Application No: EP/38/20/HH
Site Address: 23 The Plantation East Preston BN16 1LD
Description of works: Single storey rear extension and conversion of roofspace to habitable use to include front, side and rear rooflights.

Thank you for your internet representation made on 29th May 2020 which has been recorded as no objection with the comments as follows:

Project	
23 THE PLANTATION, EAST PRESTON	
Proposed rear extension and loft conversion	
Client	
Mr & Mrs Lopez	
Drawing no. EP/TP/04	
Scale AS SHOWN	Date Feb 2020
Drawn By WG

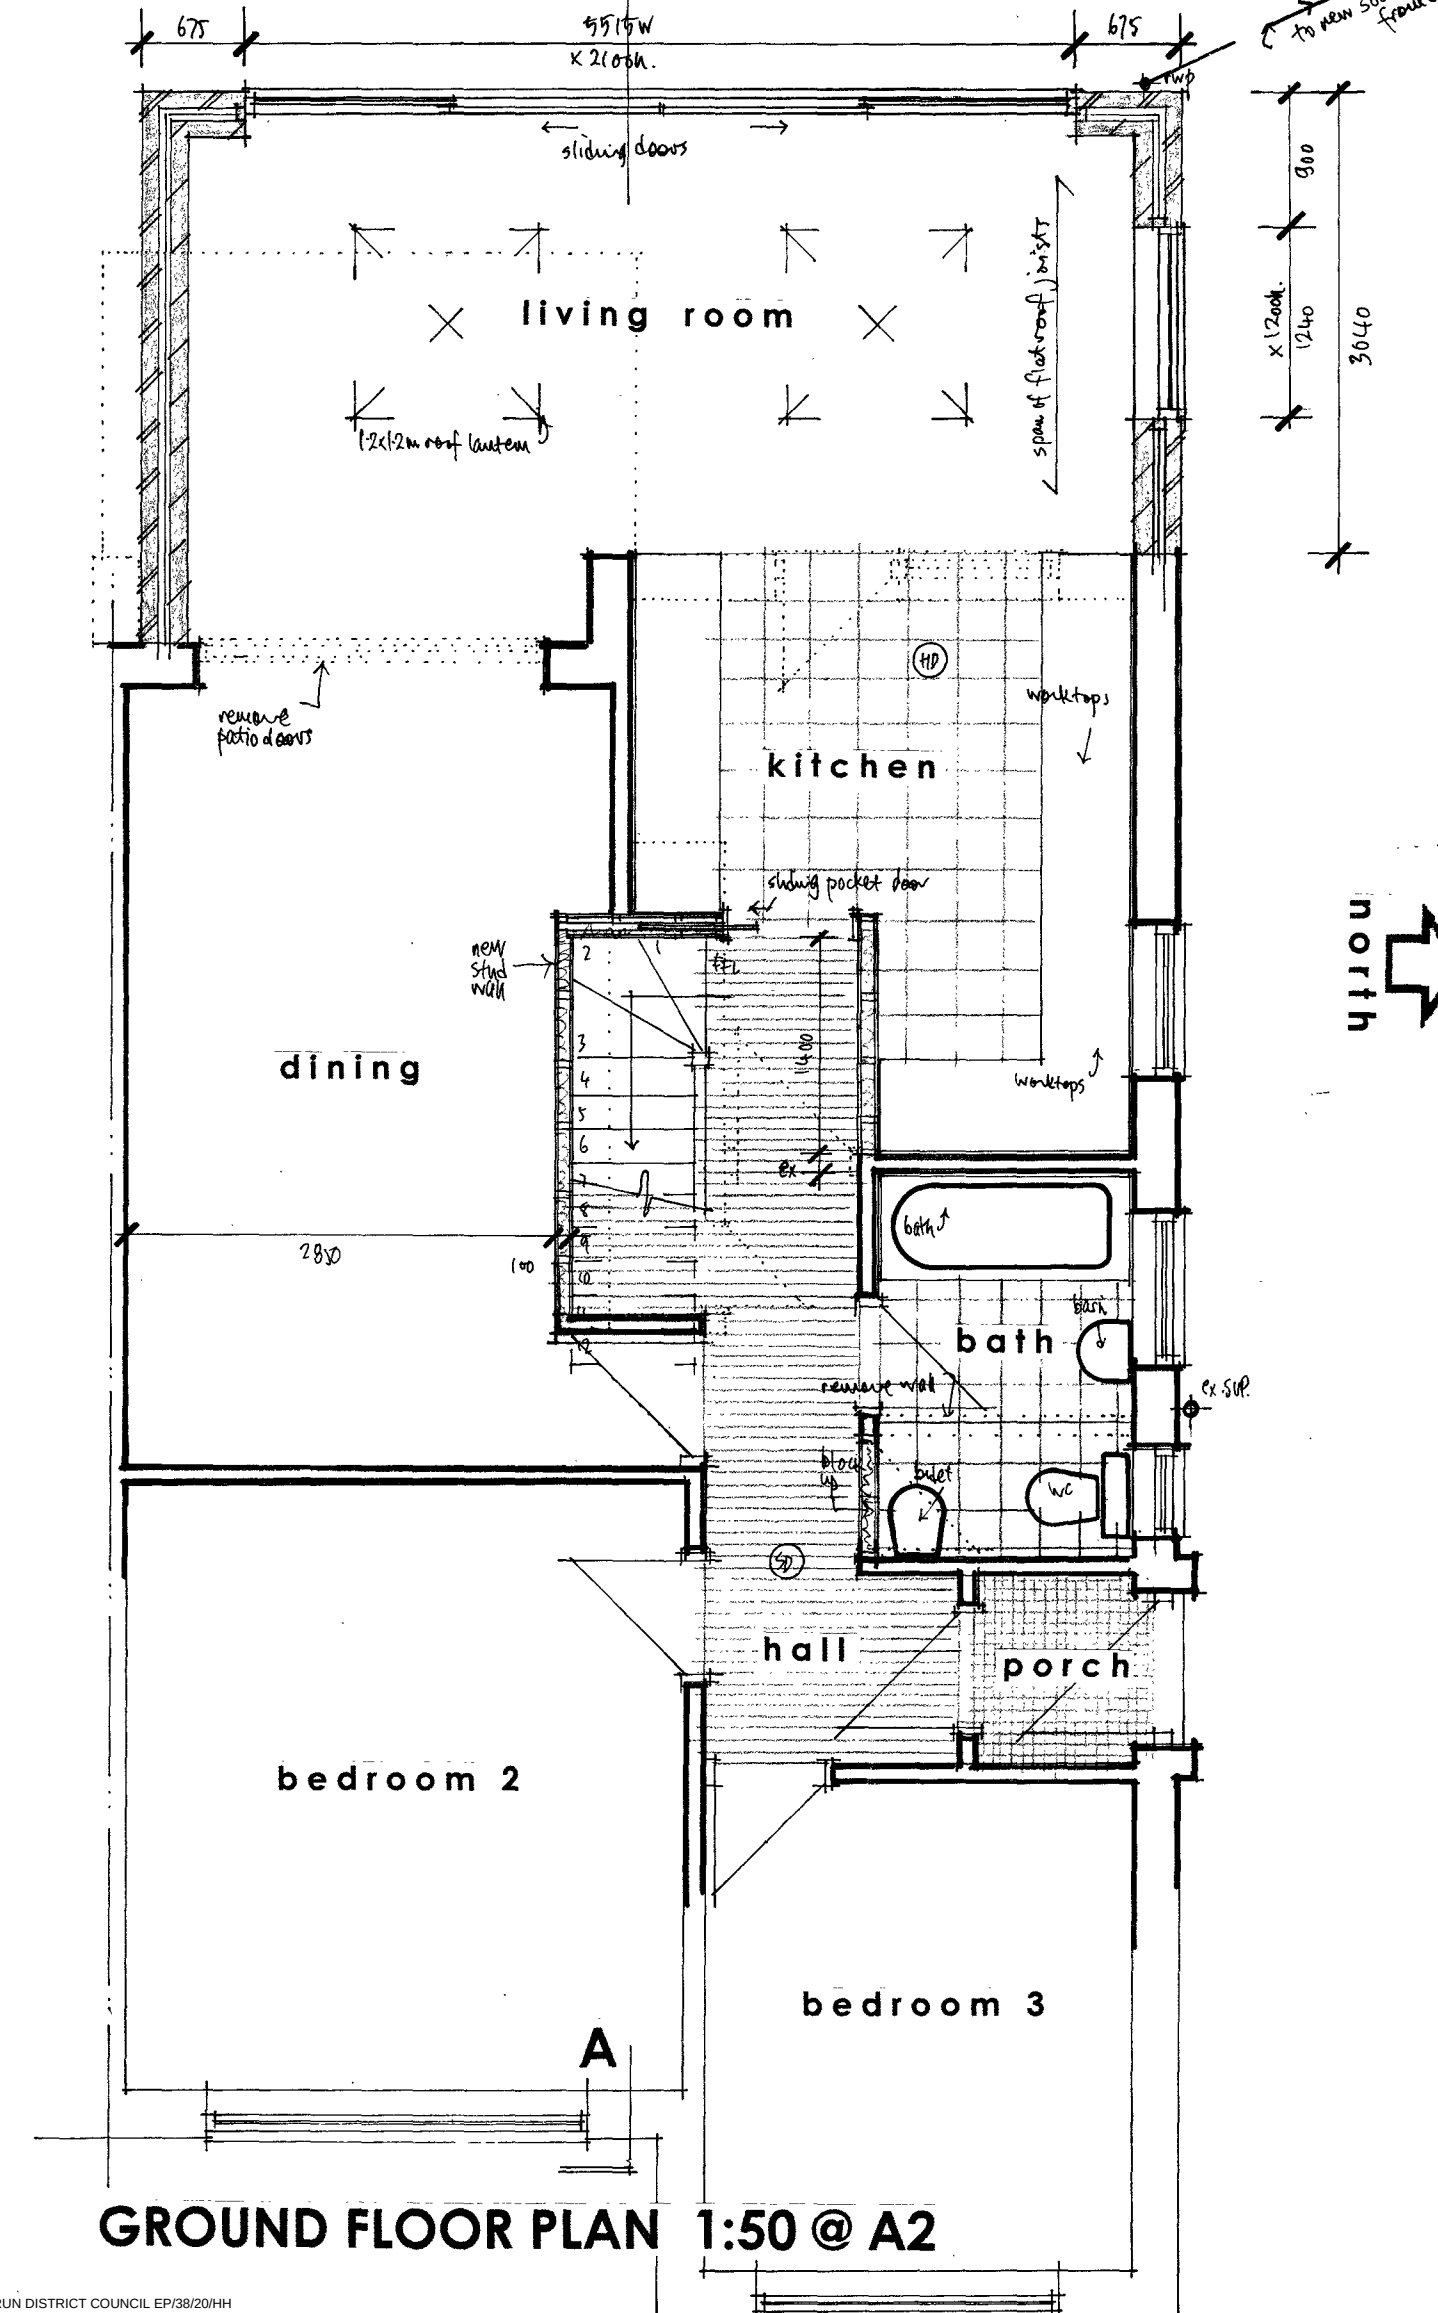
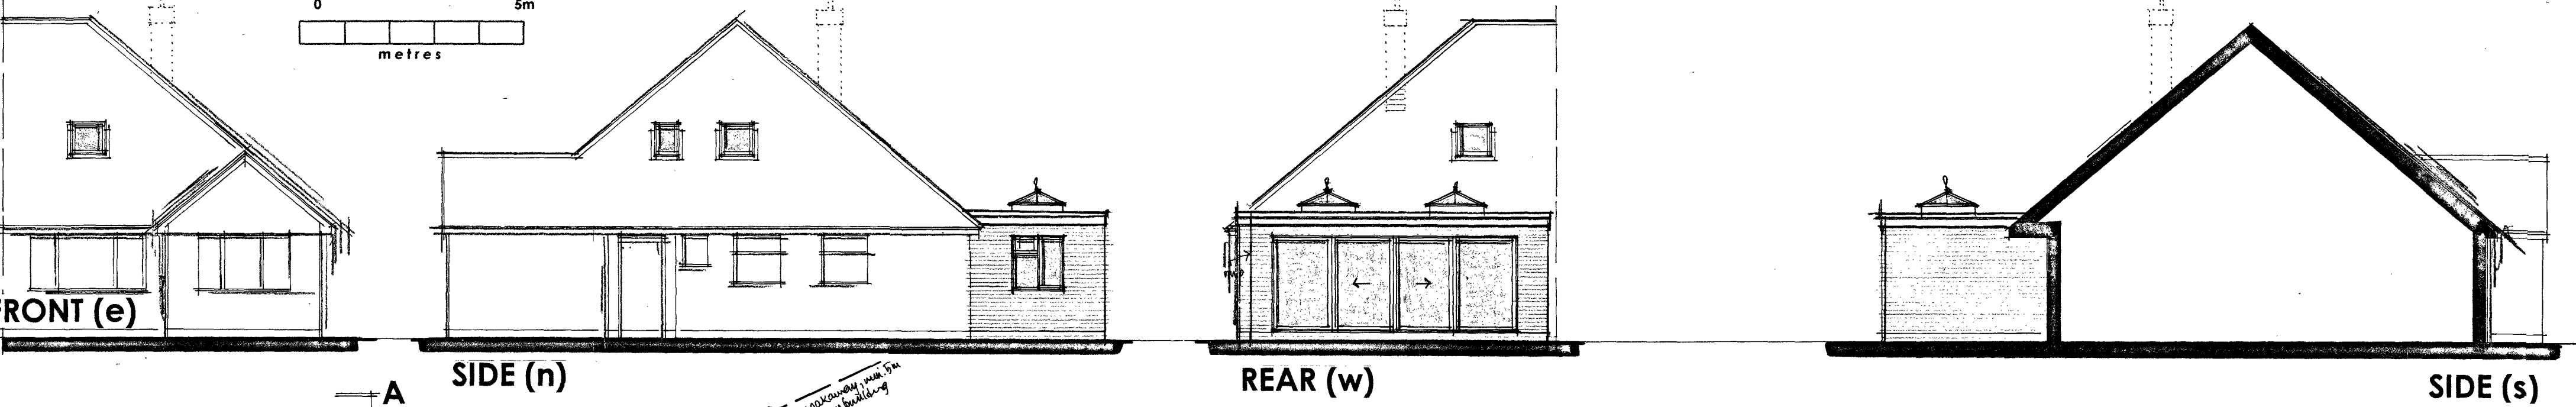
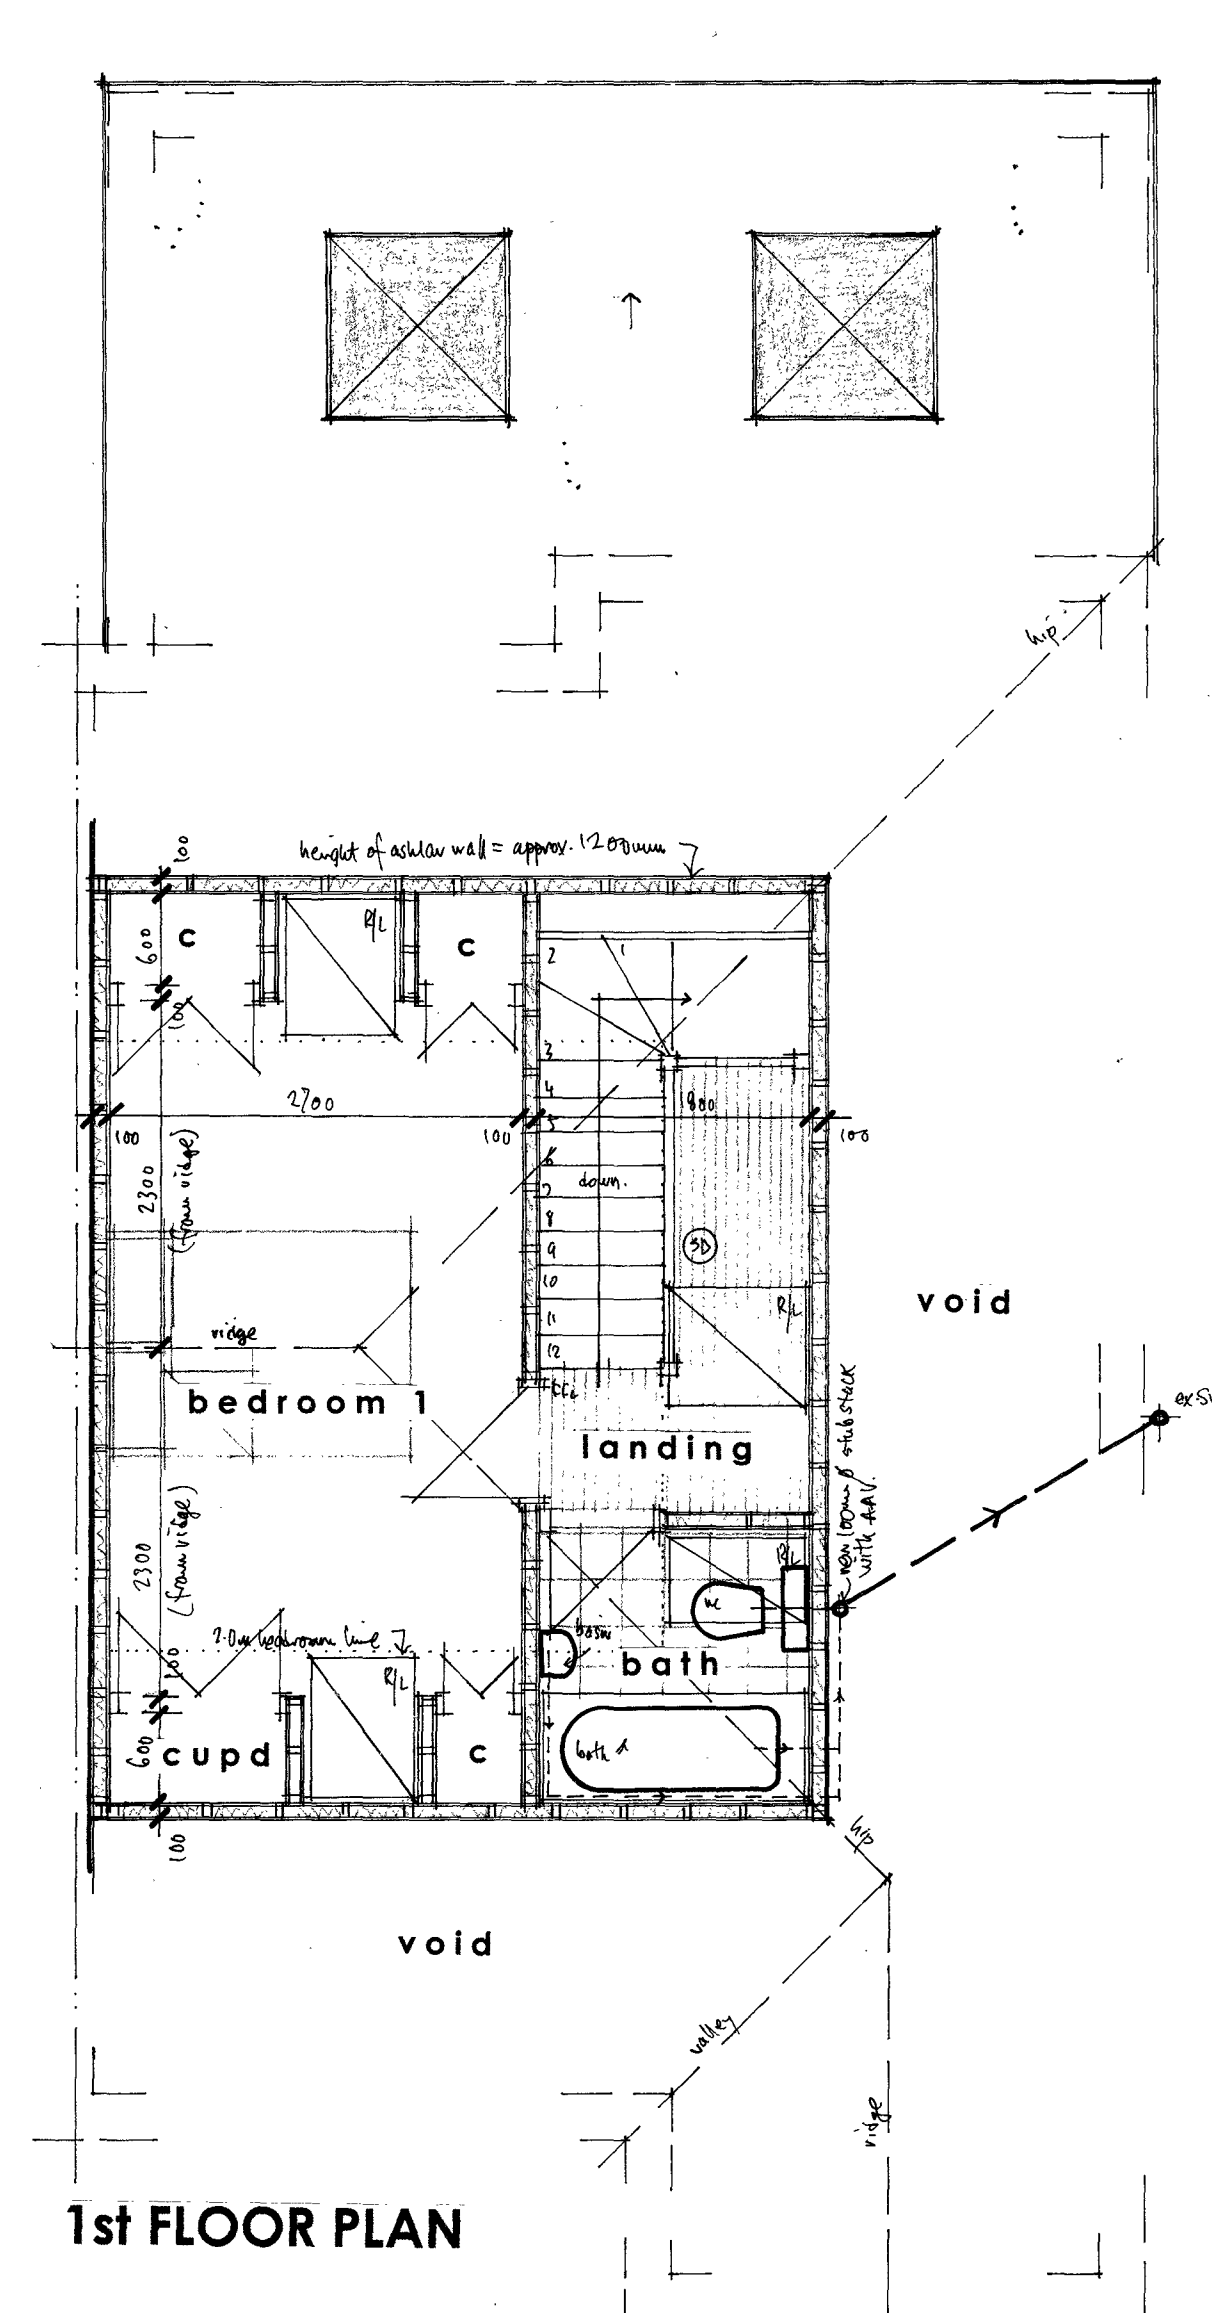
1.6 At the rear of the properties no consideration has been given to the existing arrangement of the two rear extensions the roofs of which are joined.

There will need to be a party wall award under the Party Wall Act to work through these issues and I would request that submitting a copy of the award to the Local Planning Authority be included as a pre-commencement condition.
